Our Ref: R/2016/1/C
File No: MP 08_0098 MOD 13

Modification Request for The Star (MP08_0098 MOD 13) – 20-80 Pyrmont Street, Pyrmont

The City of Sydney (the City) has reviewed the information provided as part of the public exhibition and **objects** to the Section 75W modification of the project approval.

1 ELEVATION Typical Elevation
1:20

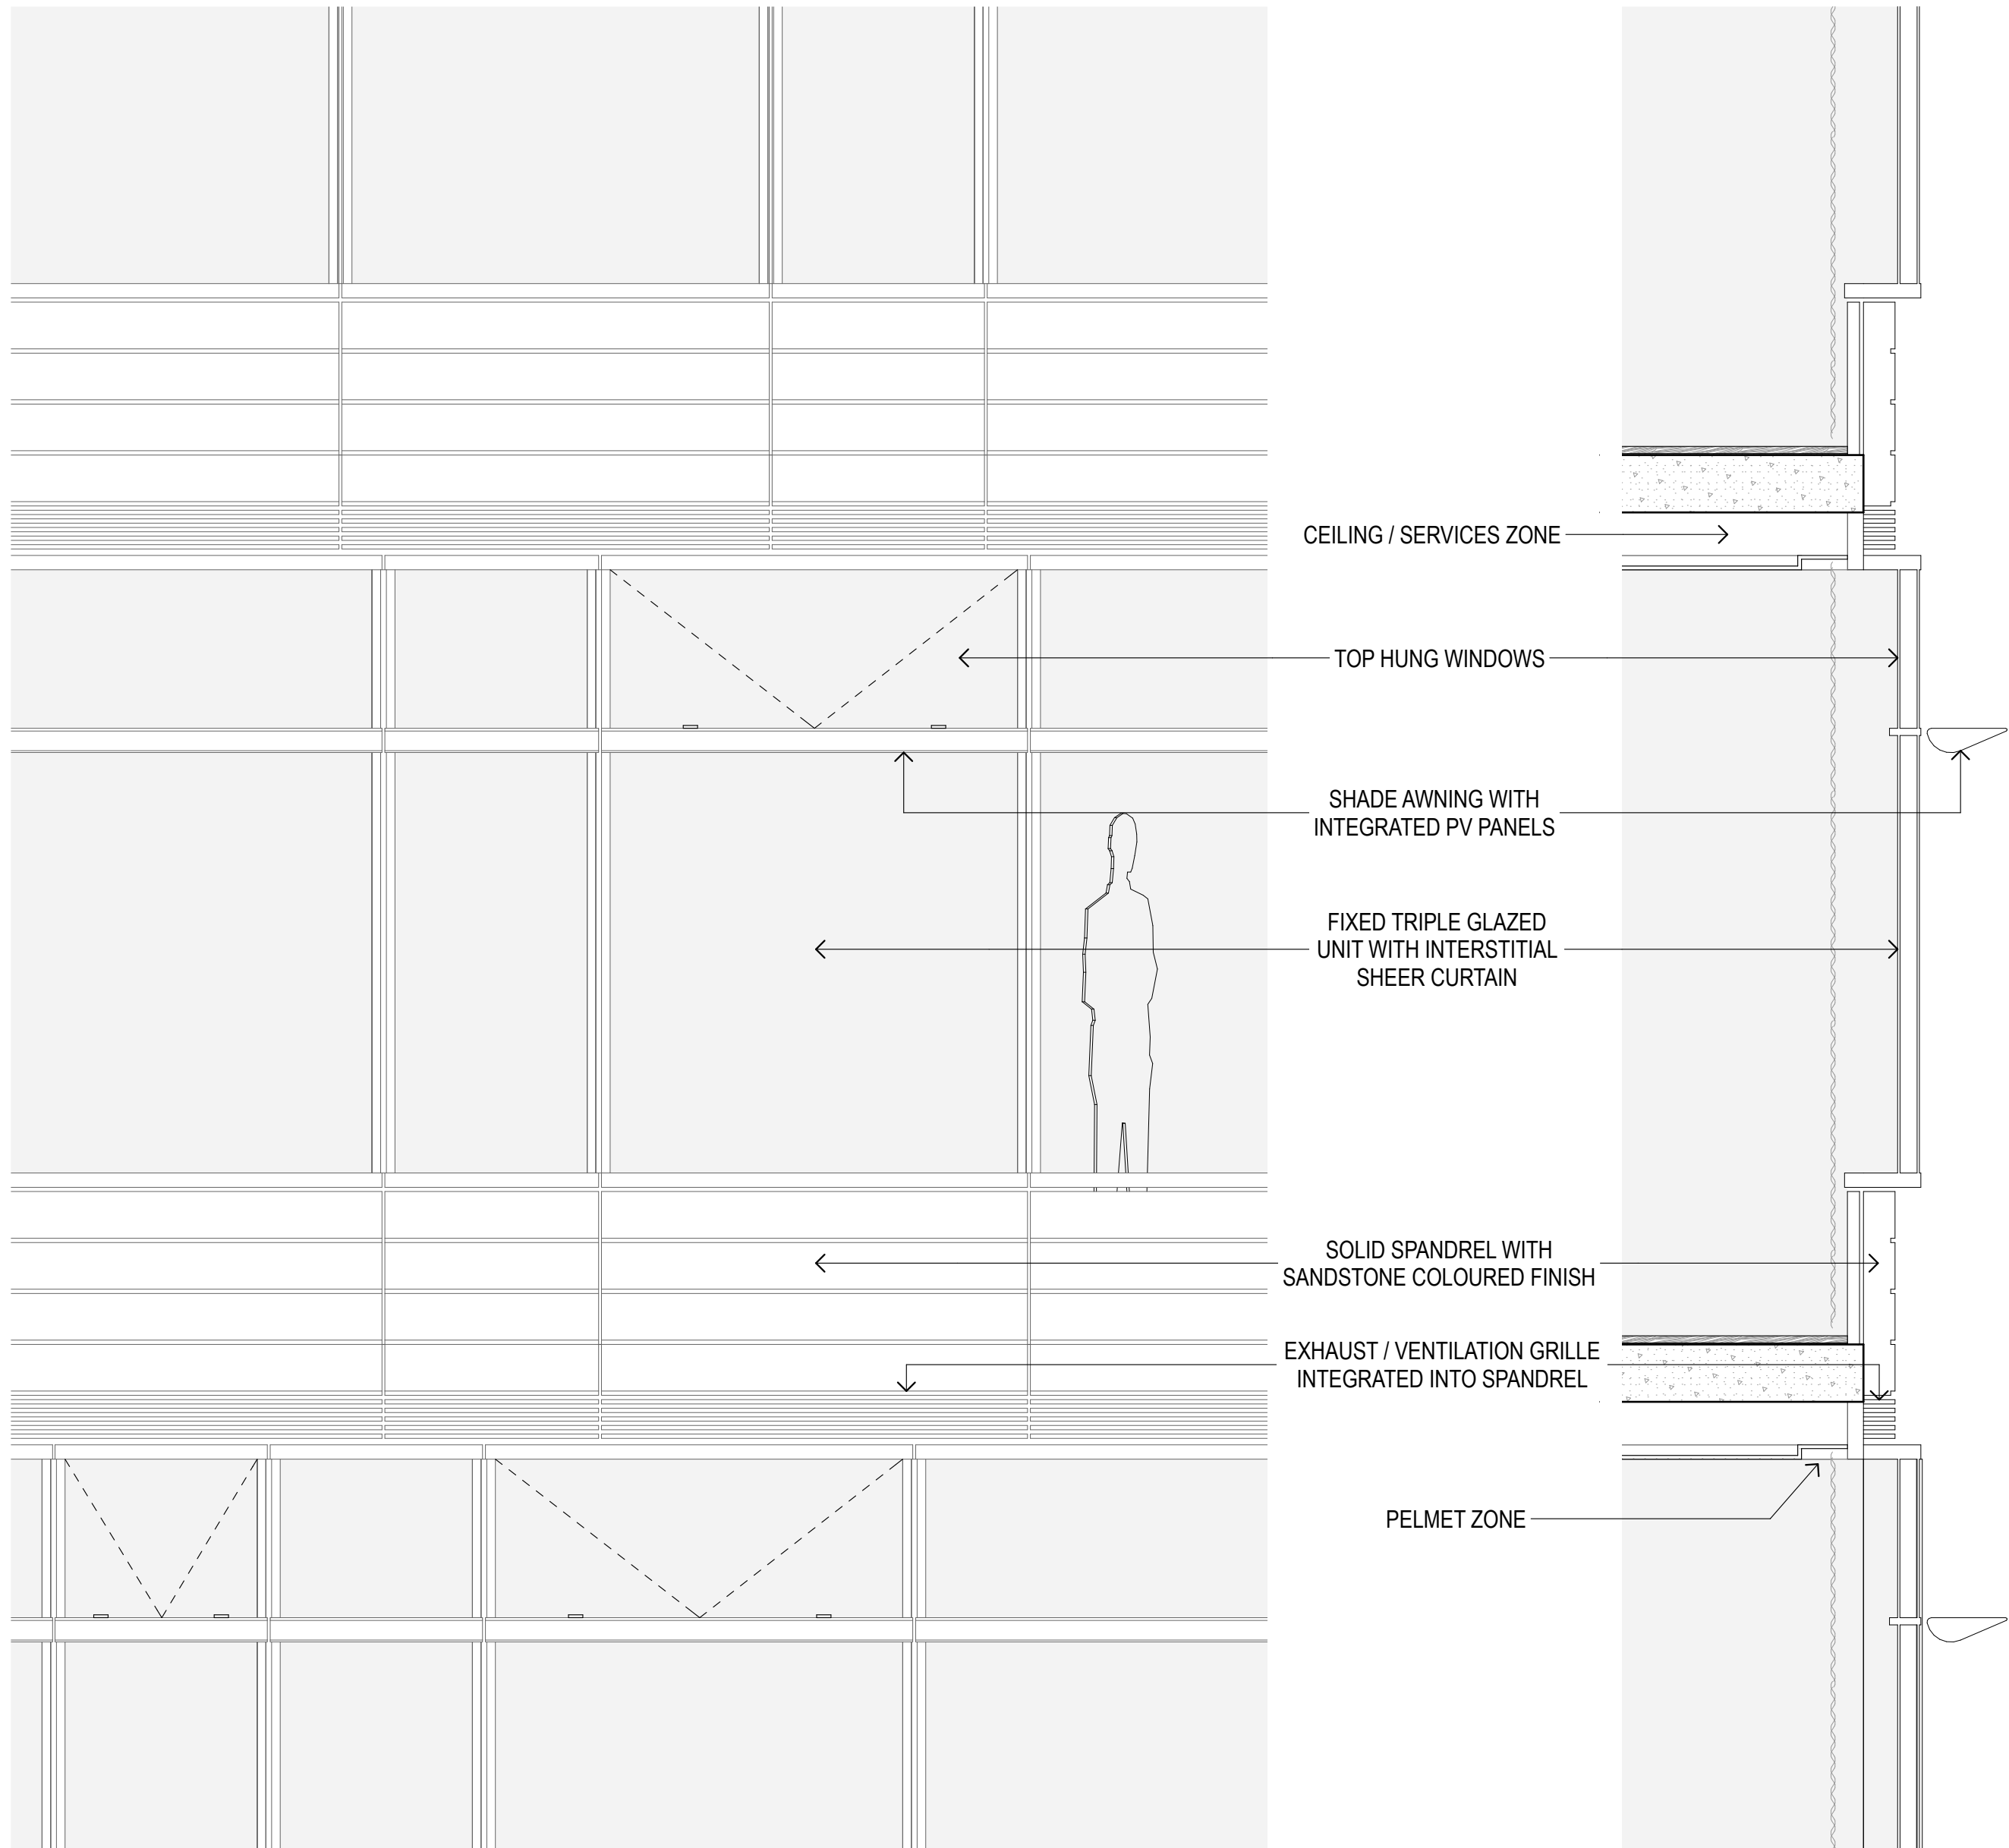
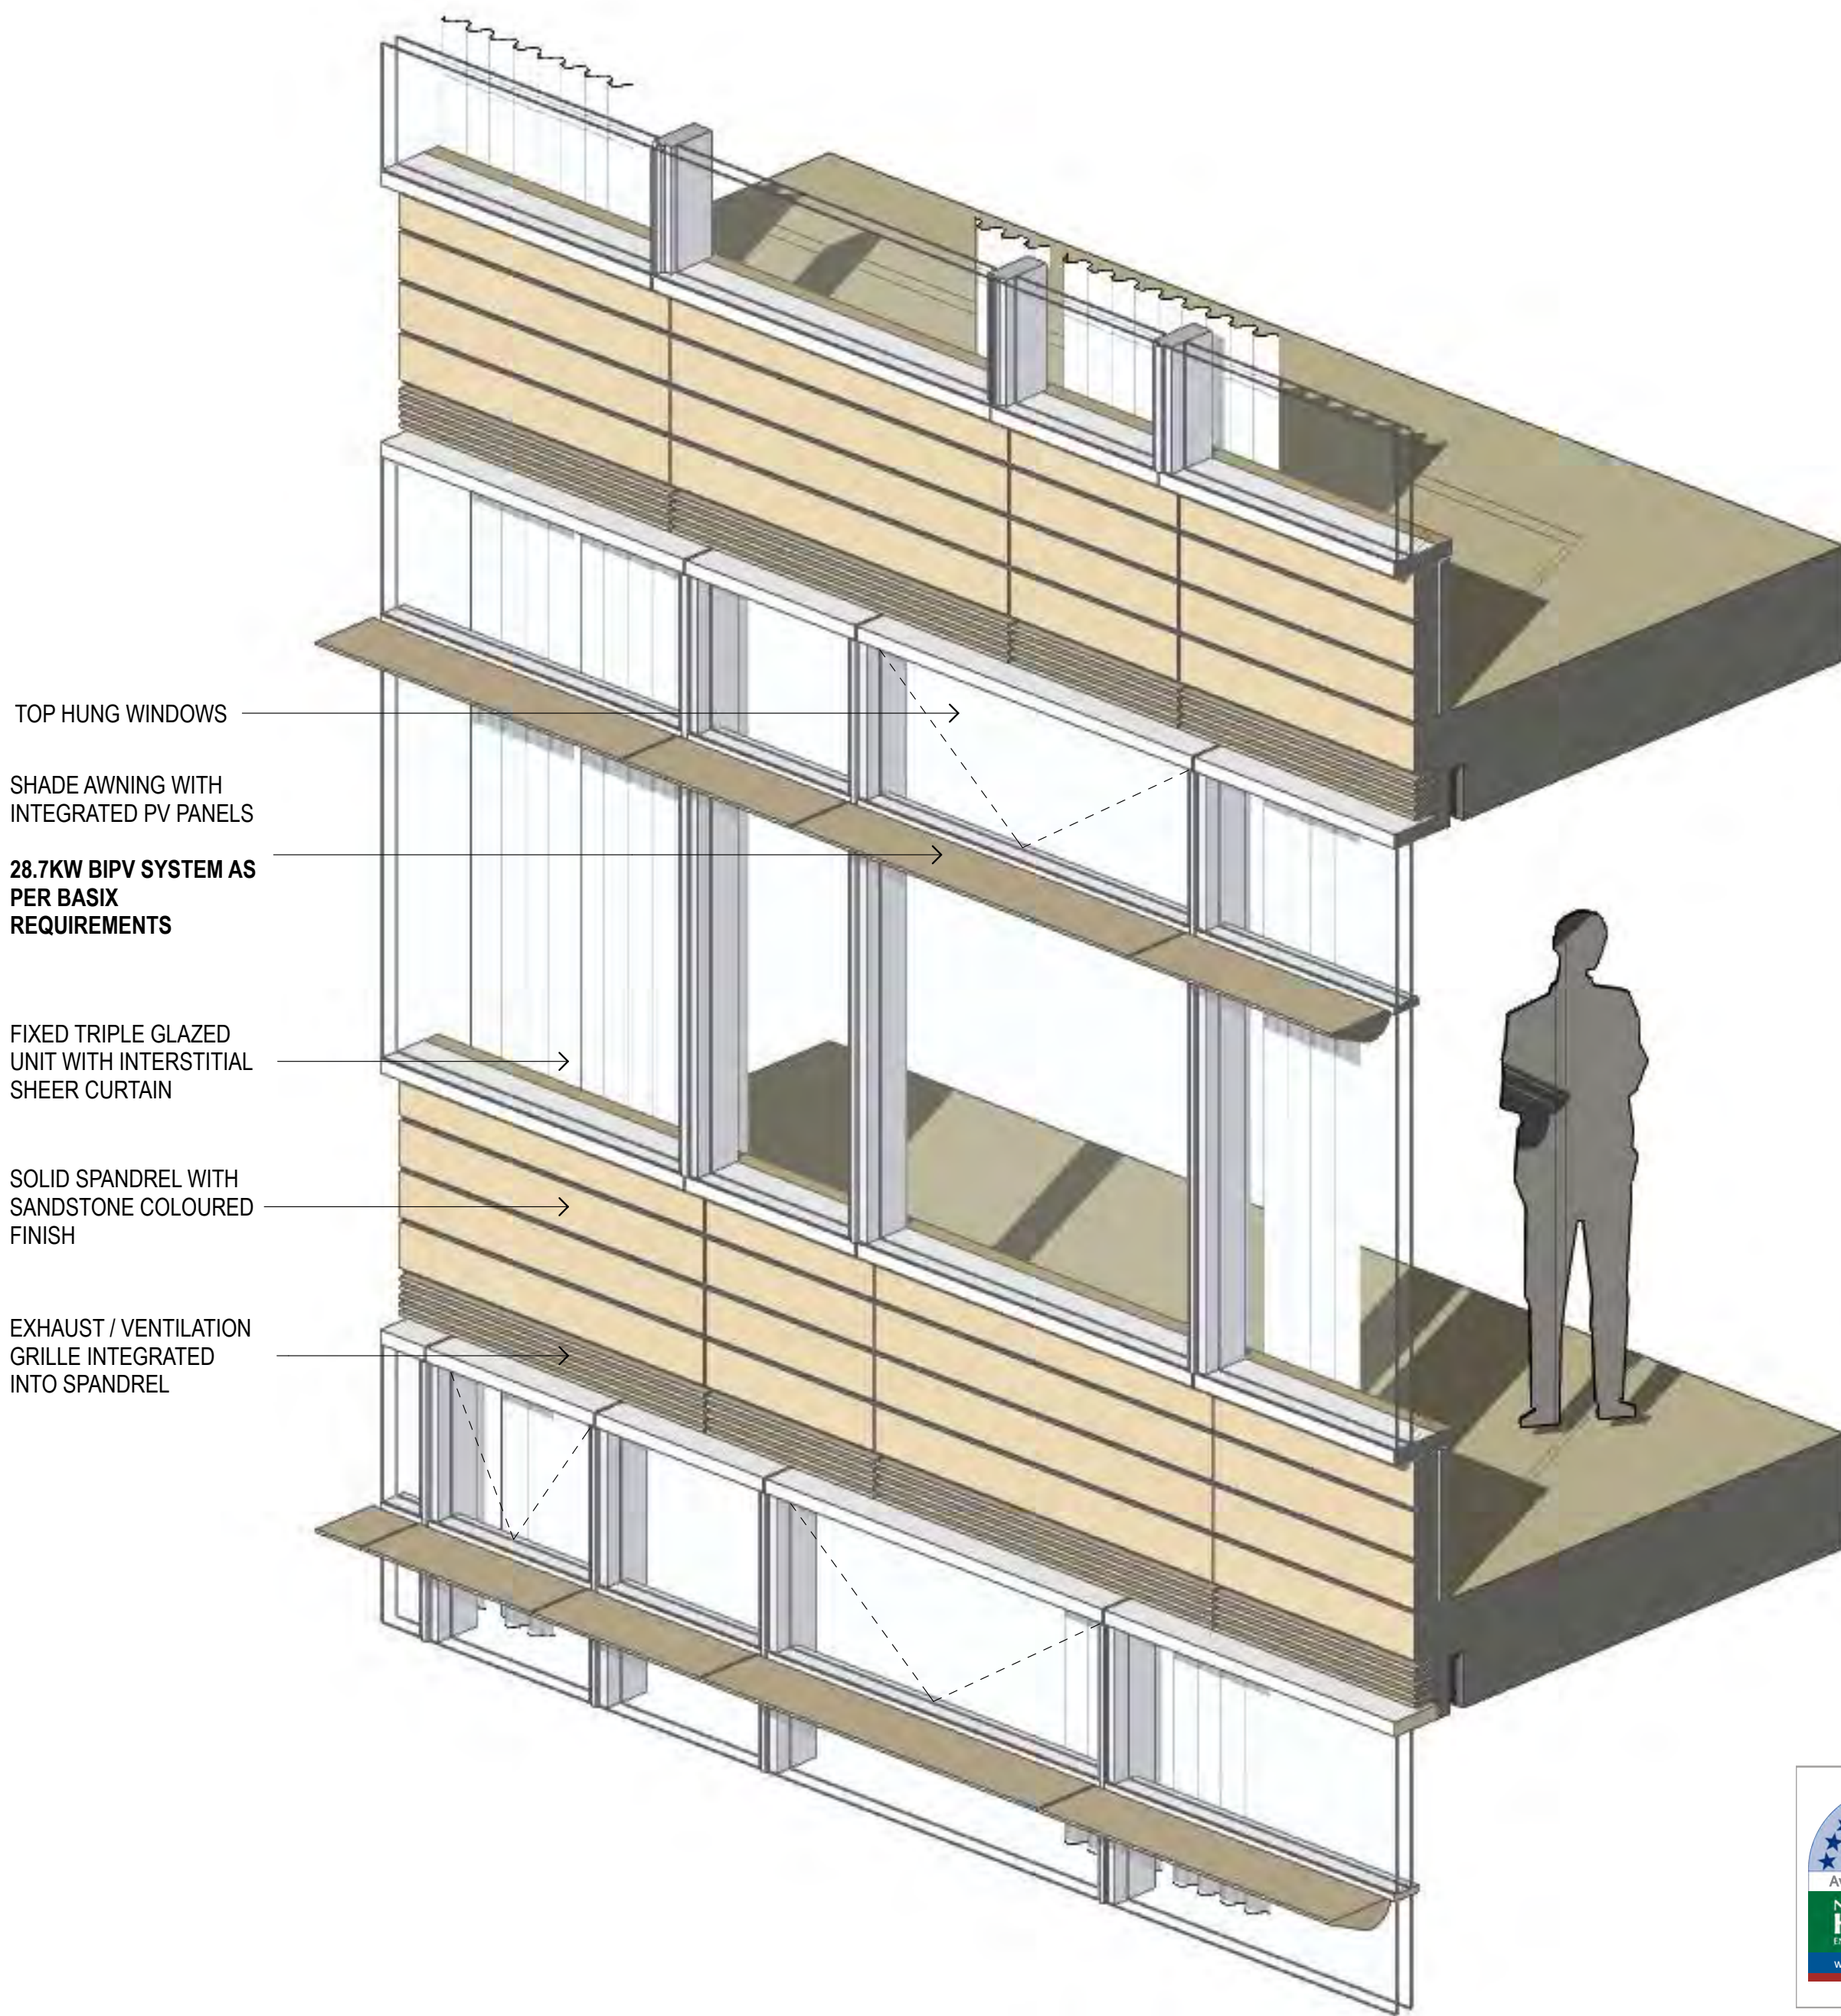
- Inadequate detail has been provided to establish how the natural ventilation requirements of the ADG will be met. The architectural plans do not show *any* operable windows to apartments. All glazing, including to wintergardens, is drawn in plan to appear as a curtain wall. This provides an unacceptable level of amenity.
